Application: SSI 7485

I am writing to you regarding the proposed modification to M4-M5 Link, Mod 2 The Crescent overpass and changes to pedestrian infrastructure in North Annandale, Rozelle and Rozelle Bay Foreshore area.

Figure 4-4 Elevation: Indicative view of The Crescent overpass

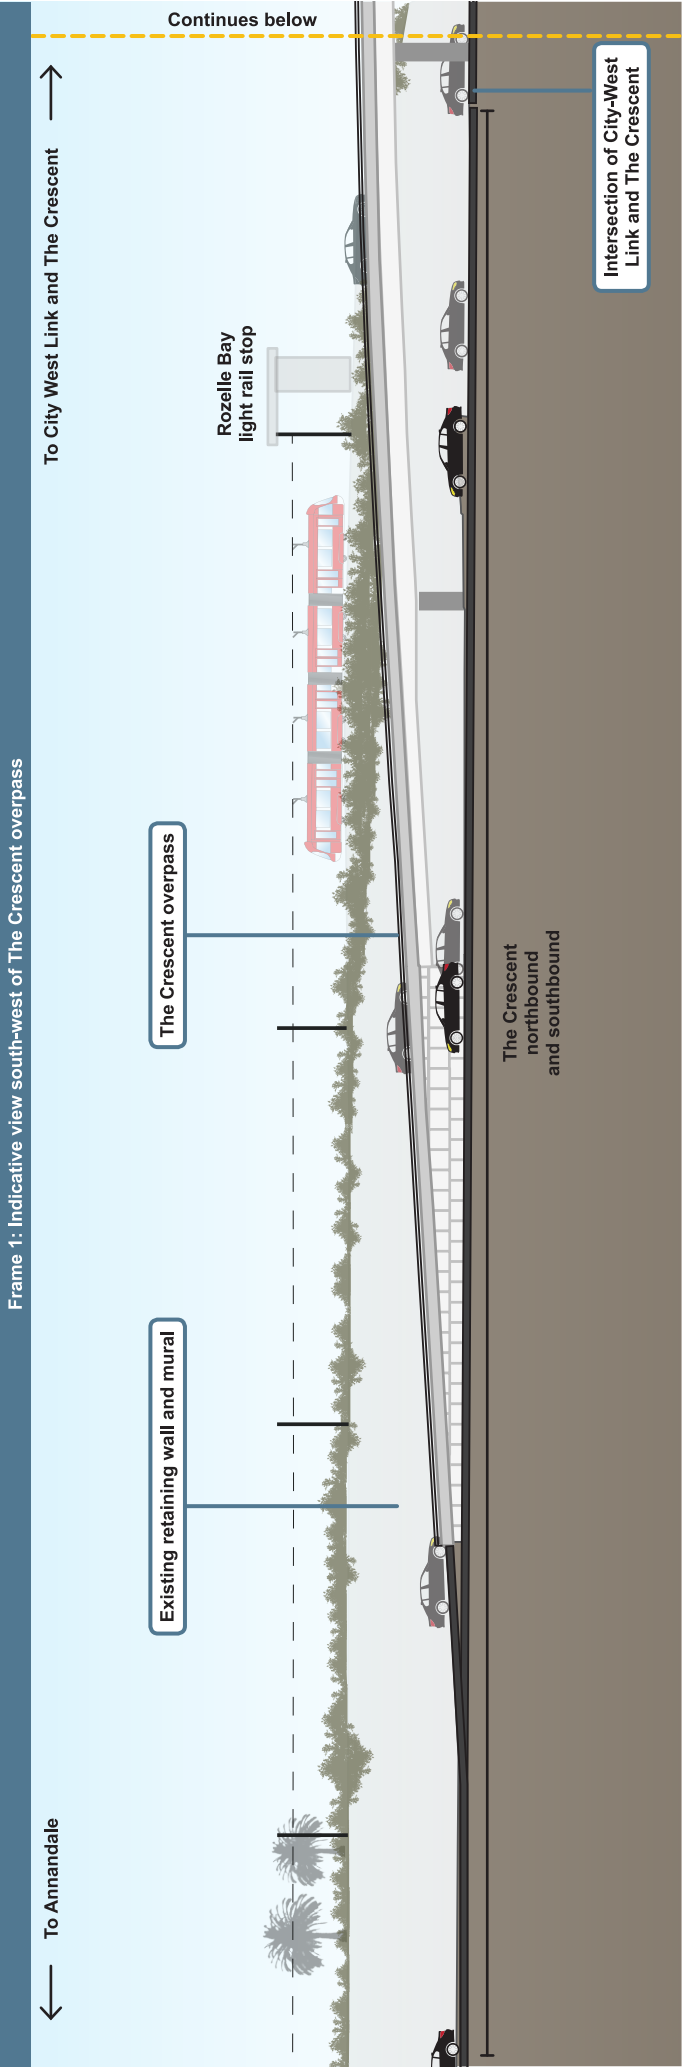
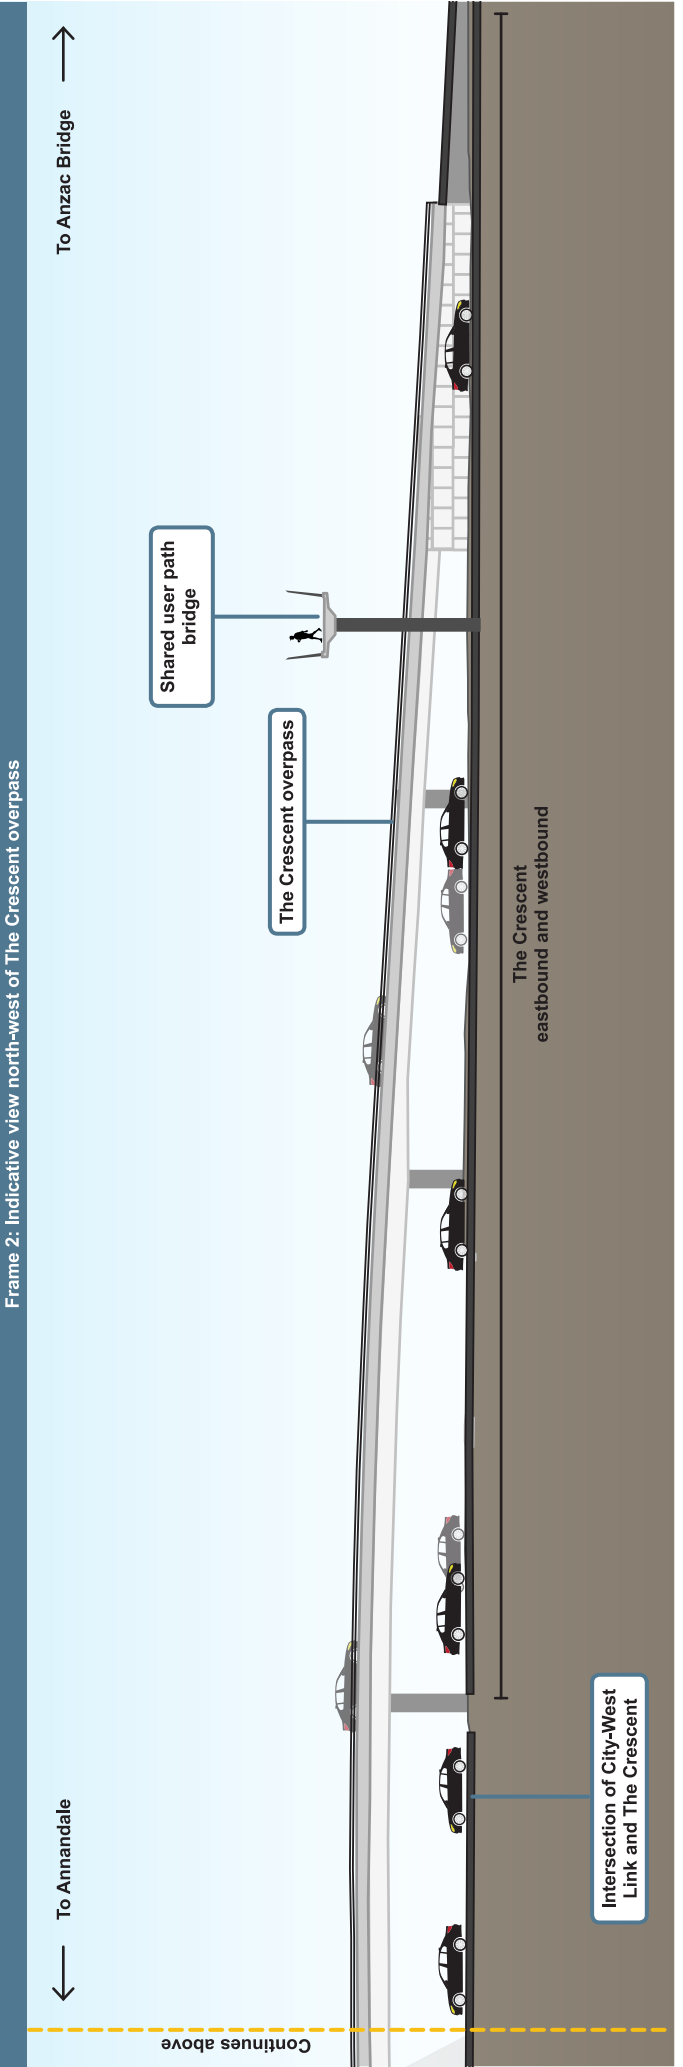
I object to the addition of a car overpass as per the modification & relocation of the Green Link

- The significantly reduced safety and increased risk for pedestrians and cyclists with removed access over The Crescent to Bicentennial Park and the increased traffic along Johnson Street.

- Being required to cross five sets of pedestrian lights at The Crescent as my option to reach the foreshore from Annandale or from Rozelle Bay light rail stop.

Figure 4-6 Elevation: Indicative view of Rozelle Rail Yards Pedestrian and Cycling Green Link

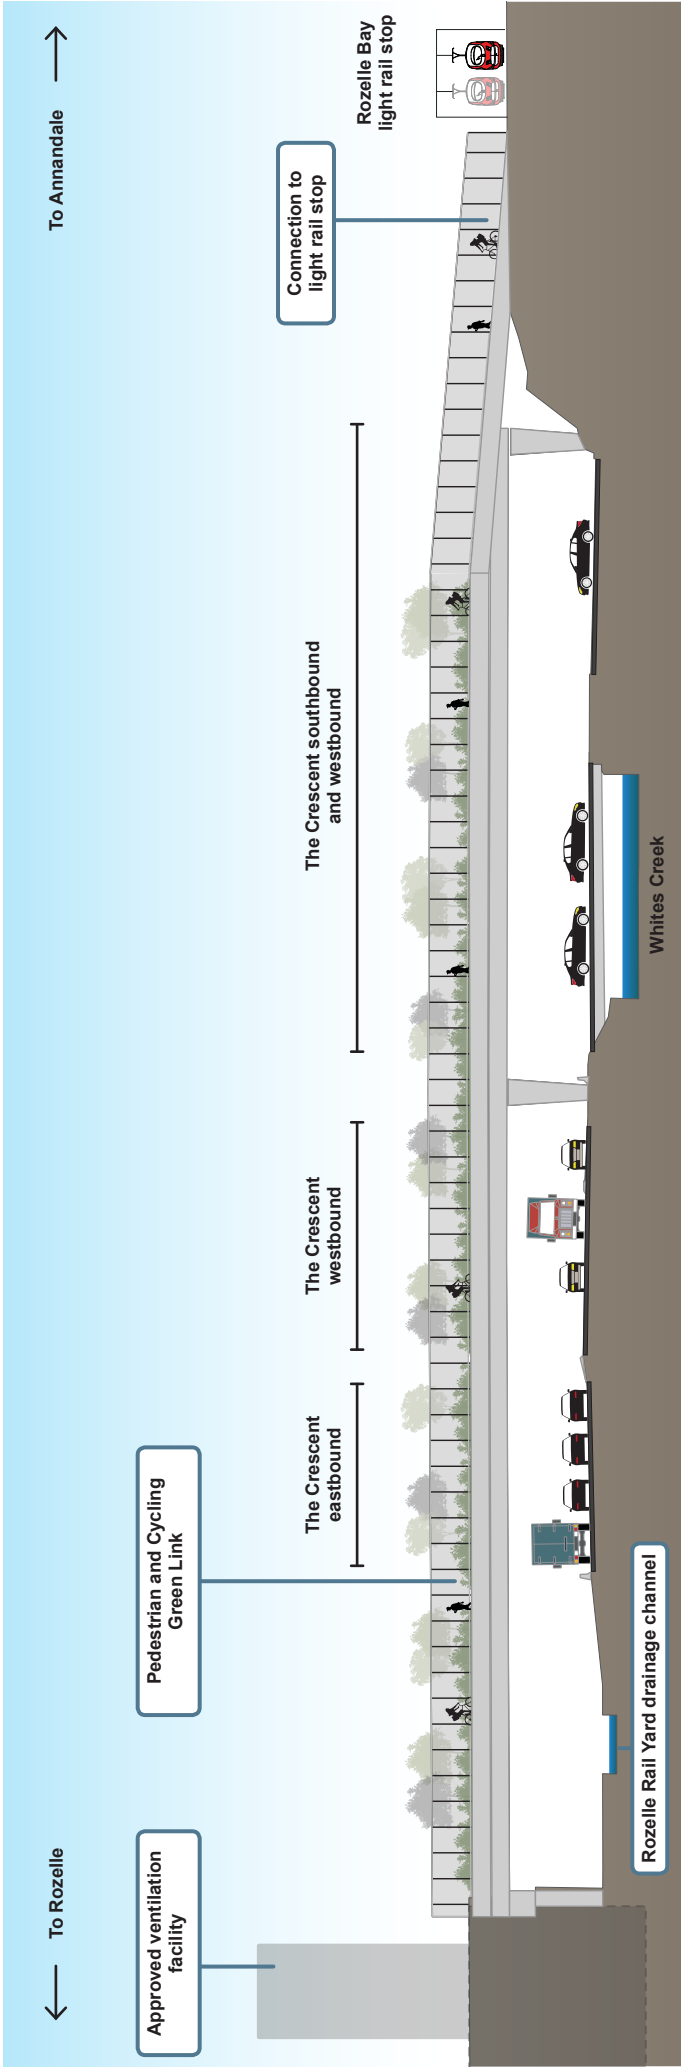
I request that RMS work with the community to explore alternative options to the proposed new car overpass design and the changed pedestrian and cyclist links. I am seeking the reinstatement of the safe, direct access from the approved EIS GreenLink to create a continuous green open space connection from the Rozelle Rail yards and Annandale to the foreshore. The GreenLink was more than just a walkway – it put people central to the design, maximising safety, and providing much-needed accessible open space for the community now and into the future Bays Precinct design.

- Reinststate the GreenLink connecting communities and green open space from Rozelle to Bicentennial Park
- Relocate and design pedestrian and cyclist connections that are continuous, safe and direct.
- Design the modification infrastructure and active links in response to the character of the suburbs, the location of the foreshore and its potential future development.
- Provide pedestrian and cyclist paths that maximise people safety and do not force them onto busier streets, unsafe concrete plazas and caged walkways.
- Integrate active and direct connections to all active transport – including the future Metro West and Foreshore Ferry Wharf
